Our Ref: R/305/18/L
Your Ref:

Application for Listed Building Consent for Alterations, Extension or Demolition of a Listed Building

Development Garden room to rear elevation with new outbuilding to replace existing, replacement windows and resiting of bathroom from ground floor to first floor
Location Elm Cottage 30 The Street Rustington

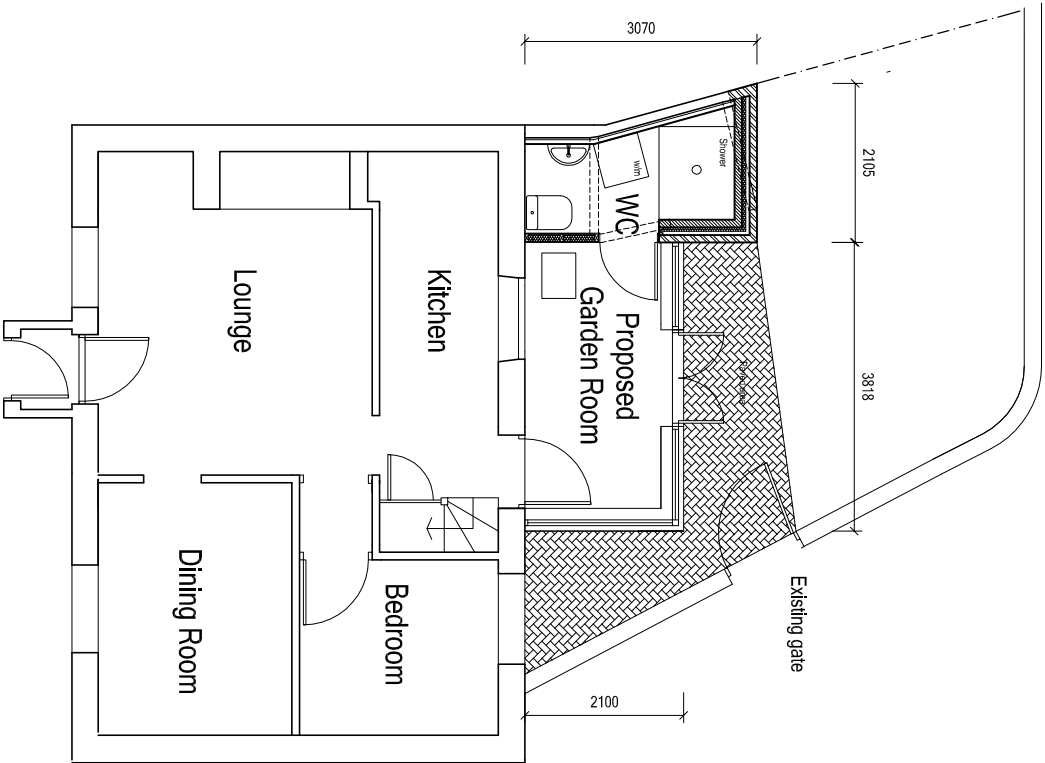
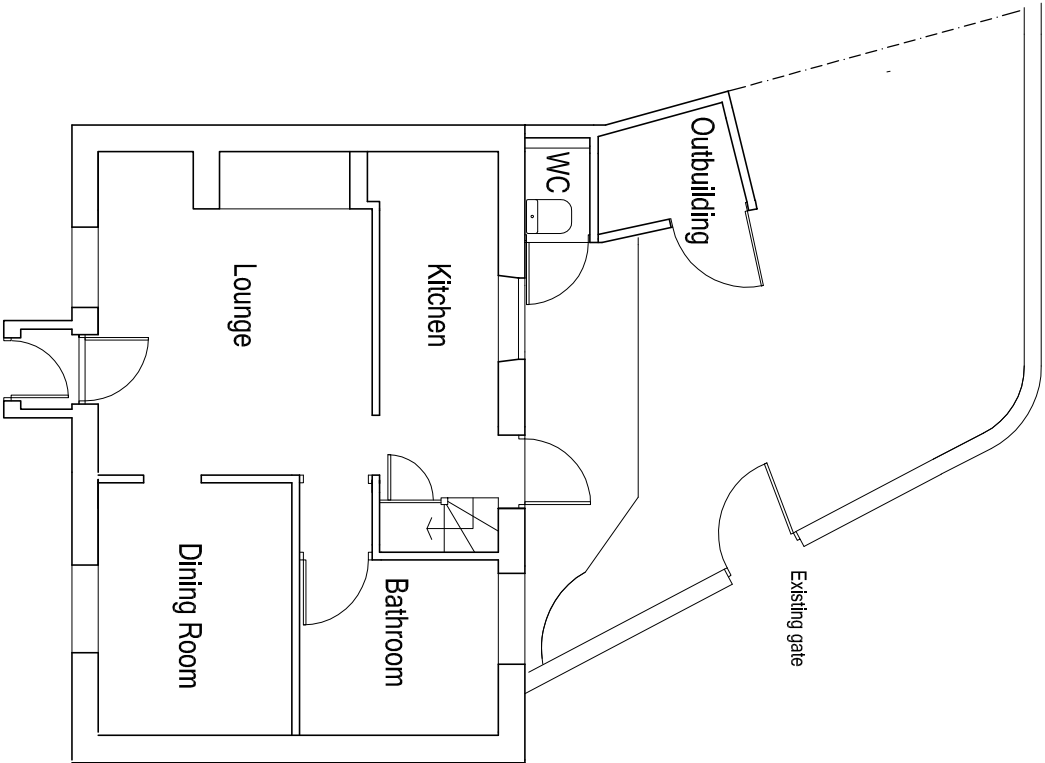
Floor Plans Required: As you are moving the bathroom from the ground floor to the first floor please provide existing and proposed floor plans to show this change. Please provide these at a standard scale of 1:50 or 1:100.

BLOCKPLAN 1:200

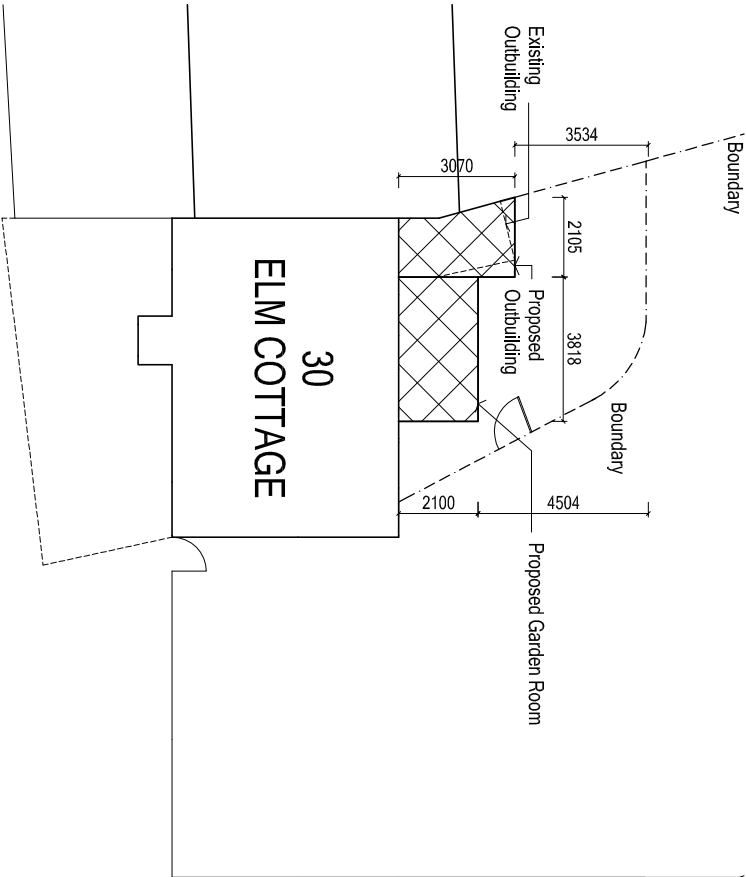
Dimensions: You are required to include a dimension from the extension to the rear boundary on the block plan.
